# KITITAS COUNTY

## DEPARTMENT OF PUBLIC WORKS

### MEMORANDUM

TO: Community Development Services  
FROM: Taylor Gustafson, Environmental/Transportation Planner   
DATE: June 1, 2018  
SUBJECT: Garrison BL-18-00006

# BLA EXHIBIT

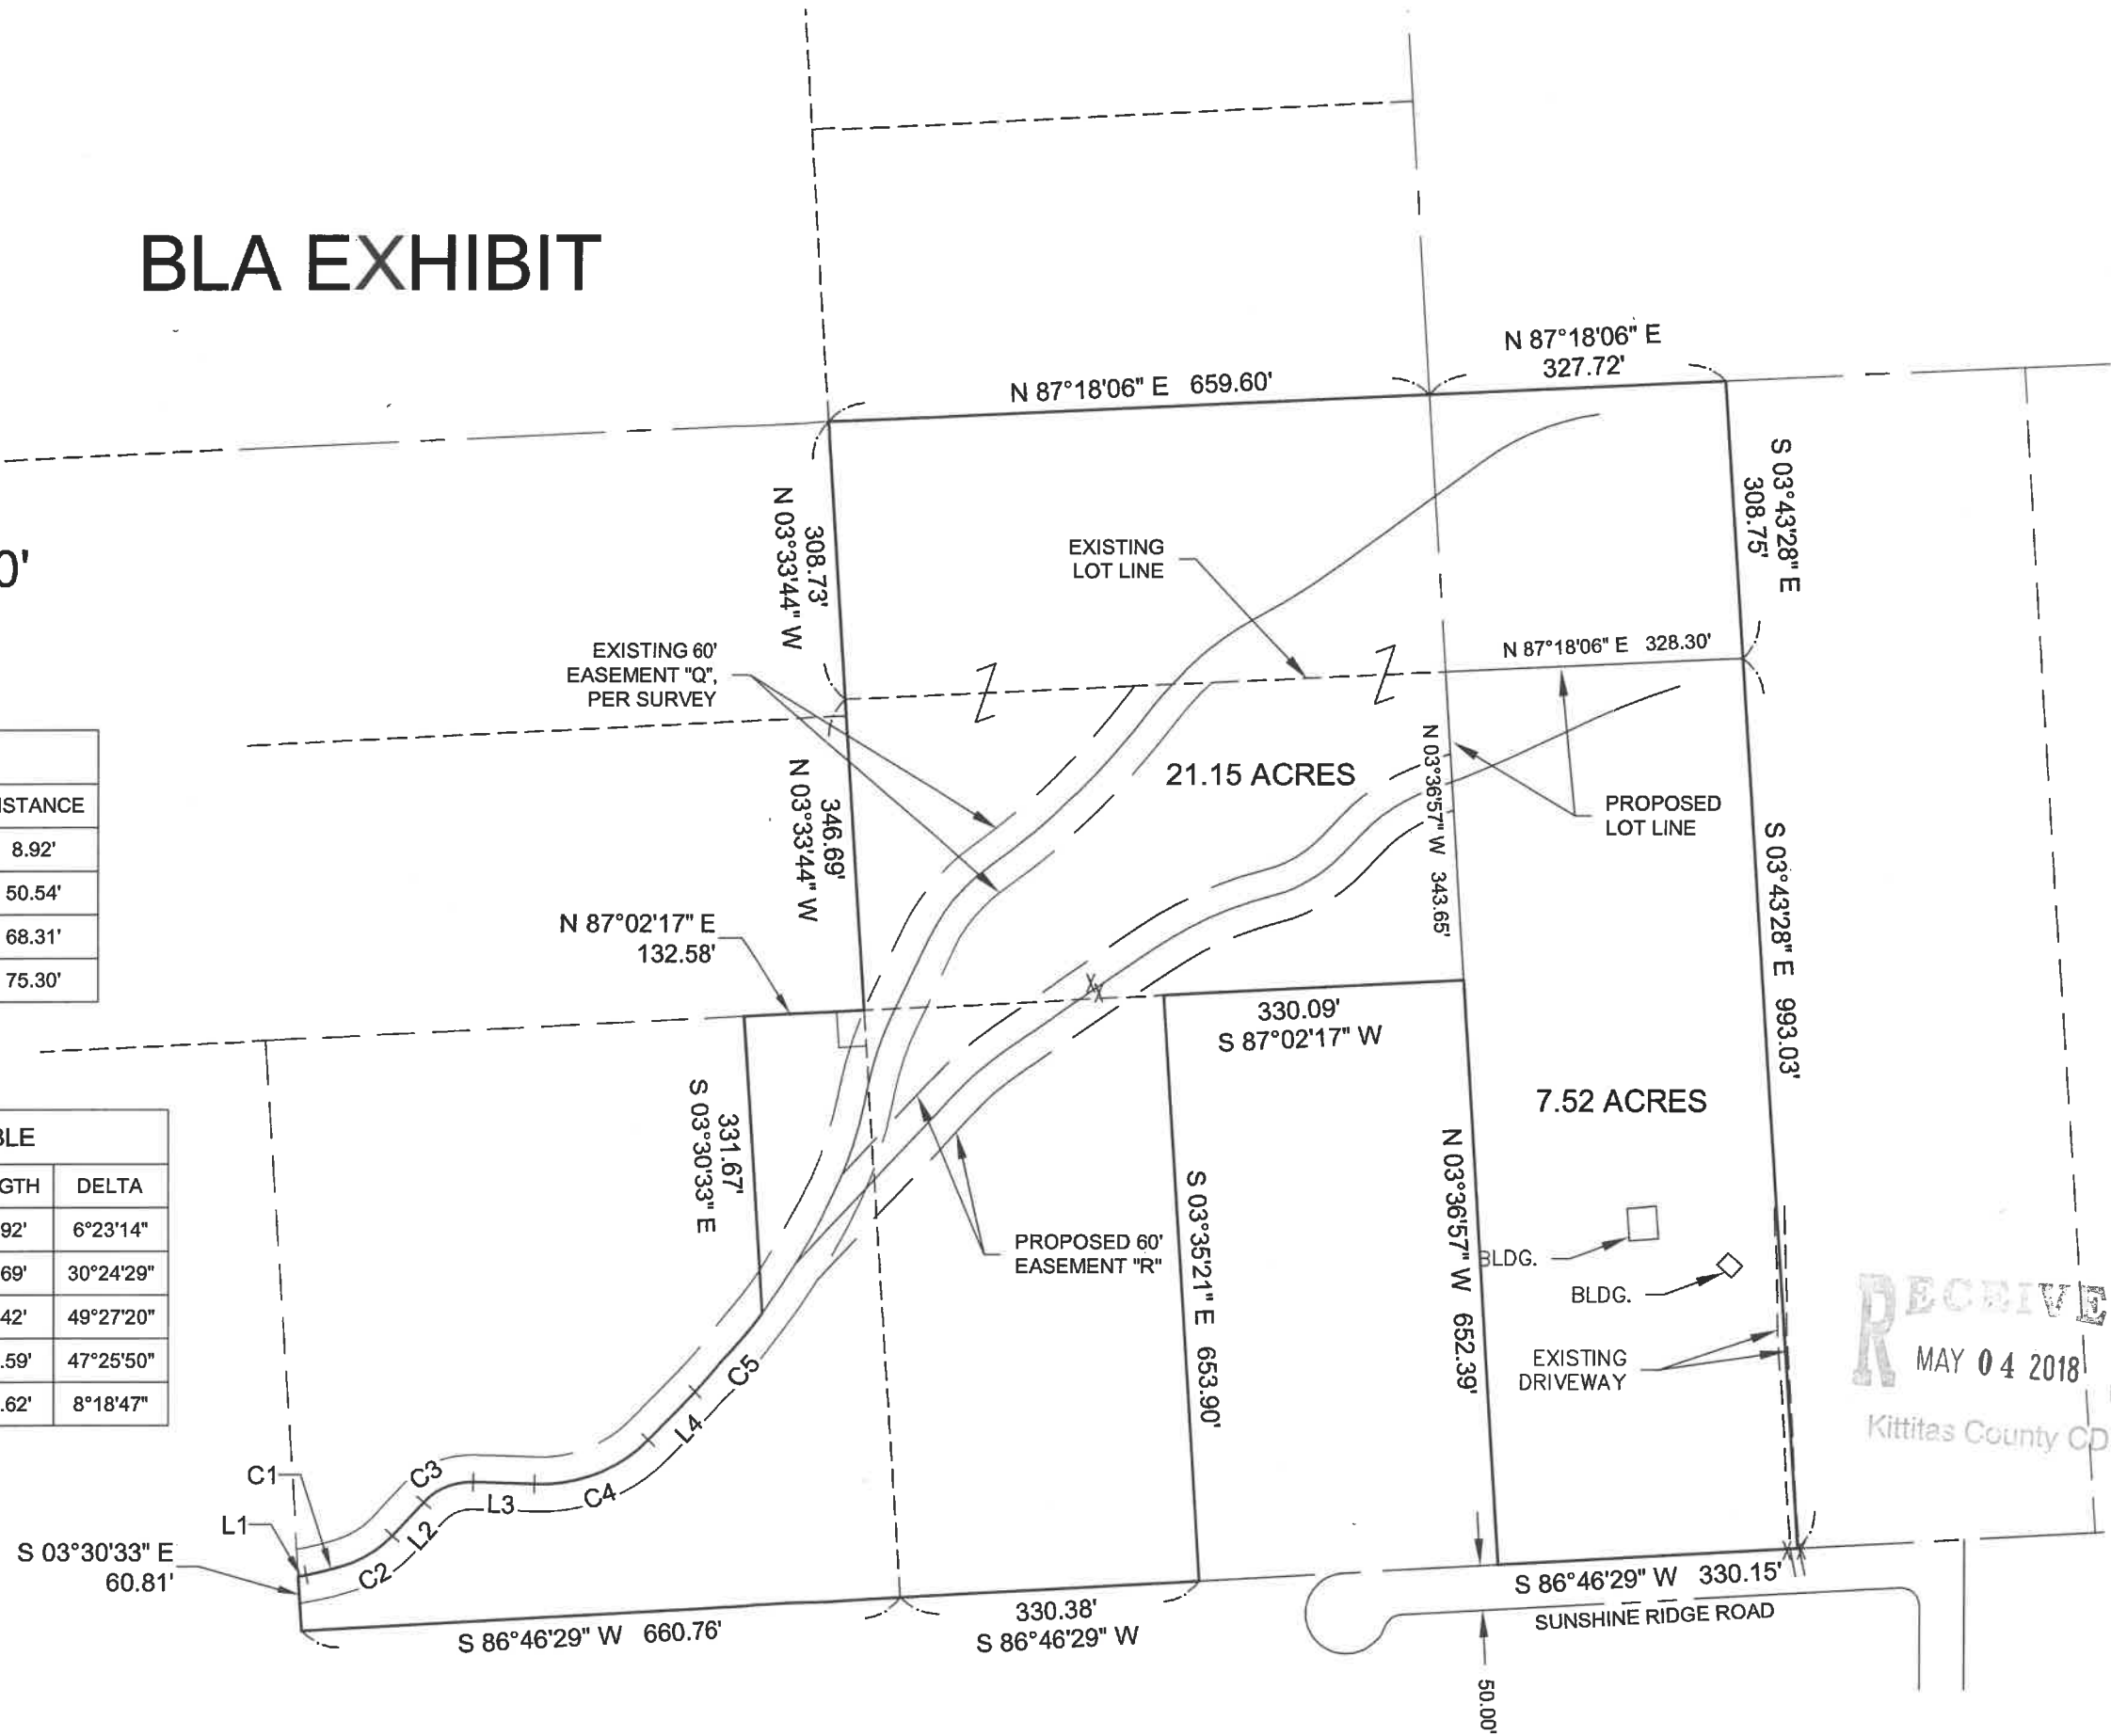
1. A revised legal description that describes the final configuration of the subject property shall be required.
2. A survey map for review
3. Show access easements on the face of the BLA including the cul-de-sacs.
